City of Albuquerque Stormwater Construction Site Inspection Report

ESC File No.	D10E002D	Project Name:	La Cuentiasta III & Stockpile		
NPDES Id. No.	NMR1004P9	Location:	Rosa Parks and Kimmick		
7/25/2022	Owner	Contractor			
Operator	Pulte Homes of NM	Guzman Construction			
Contact name & title	Kevin Patten	Rudy Guzman			
e-mail	Kevin.Patton@PulteGroup.com	rudy@guzmancs.com			
Contact Phone #	505-341-8591	505-459-3128			
COA Inspector	Doug Hughes	Start/End Time:	2-3 PM		
Construction Phase:	Staging				
Type of Inspection:	Regular	Storm Event	Past Storm Event >0.25"	311/Complaint	Follow Up
Weather at time of inspection?	Clear		Temperature:	~ 90	
Estimated date of last storm 0.25" or greater	7/12/2022

TEMPORARY EROSION AND SEDIMENT CONTROL PLAN

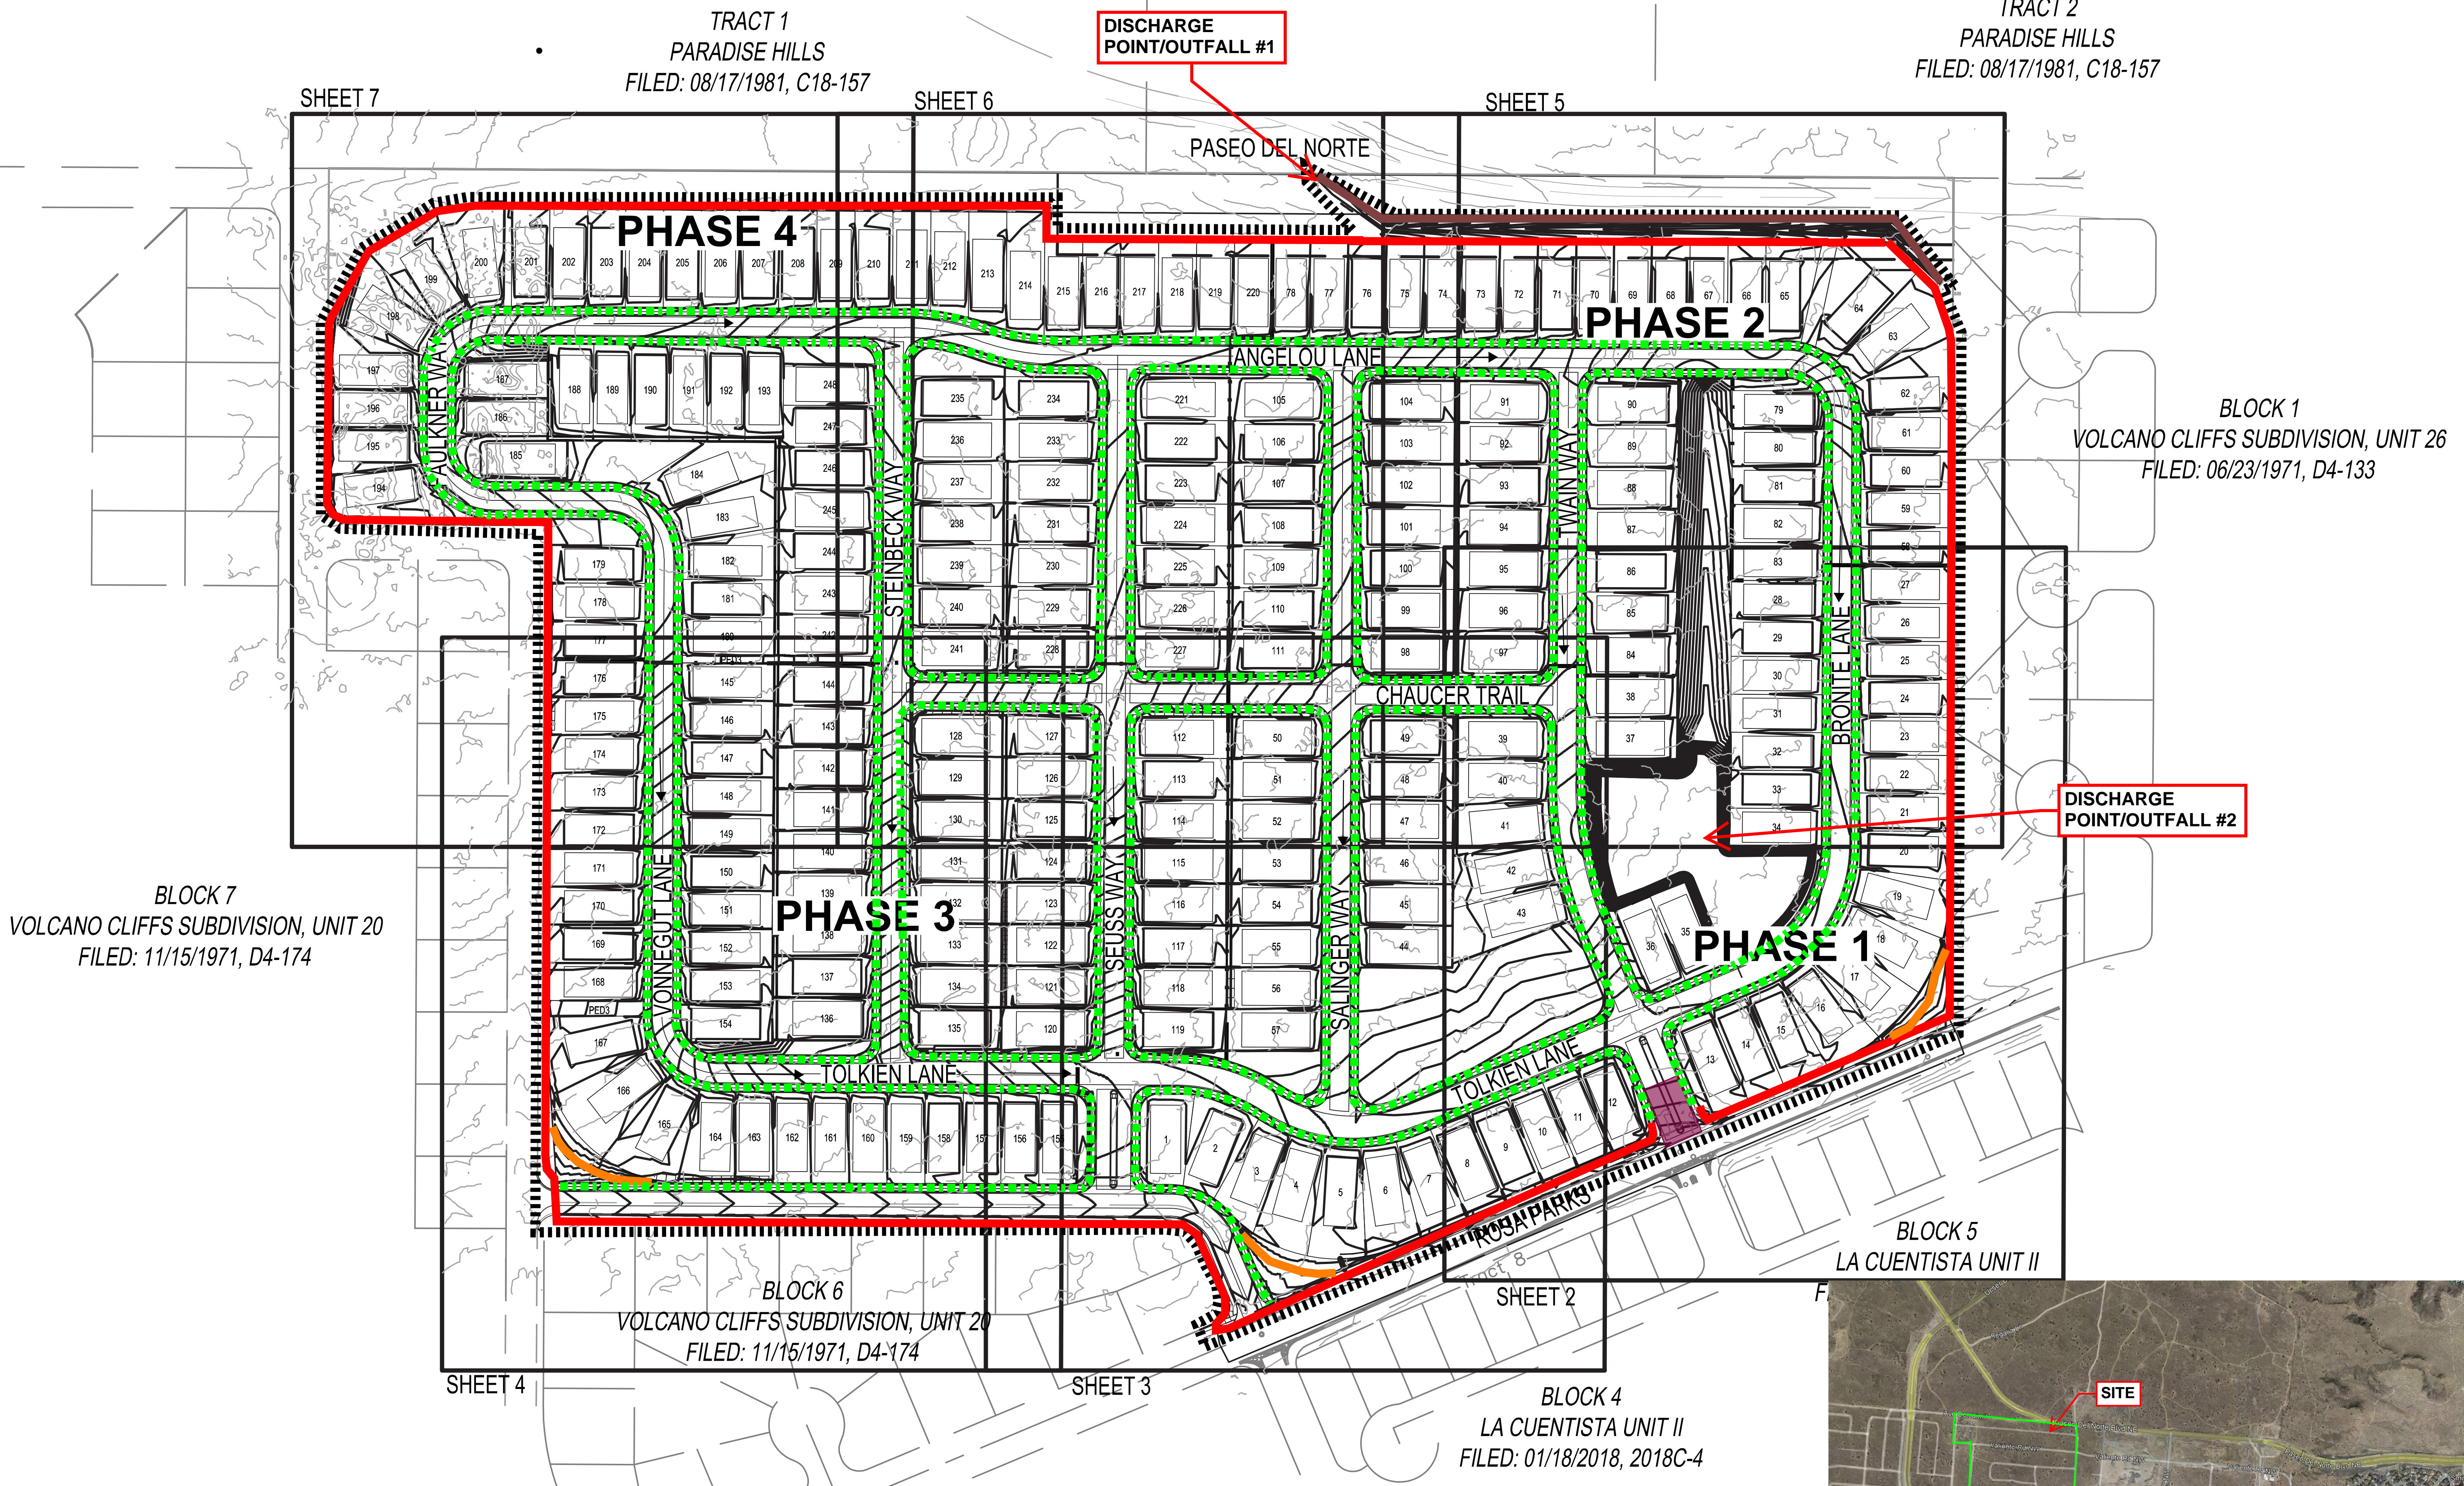
Item Number	Deficiency/ Corrective Action				
1	BMPs were missing at the staging/stockpile area.				
2	The property owner's NOIs are missing for the stockpile/staging area, so it doesn't have NPDES Permit coverage. NPDES Permit coverage is required for all disturbed areas. Tracts 1-5 Block 6 are entirely covered by recent land disturbing activities. There is also a large area of land disturbance on the portion of Tract 1 Blk 2 Plat of Tr1 Blk 2 Volcano Cliffs Subdivision Unit 26 that is due east of Tract 5 and where a water tank, porta potty, and other haul roads are located. An additional haul road is located on Tract 8 Blk 1.				
3	A SWPPP wasn't available onsite for the area of Construction Support Activities. Pulte's SWPPP didn't include the required information on the staging area (NOIs & SWPPP Map of BMPs) either.				
4

Notes:	
<p>The SWPPP is in the lockbox on Pulte's posting sign, and it is up-to-date, except the stockpile/staging area is missing. Eddie at Guzman said the new intent is to obtain permit coverage for only Tracts 4 and 5 in Block 6 and Tract 1 Block 2 and stabilize the rest with seed and aggregate mulch.</p>
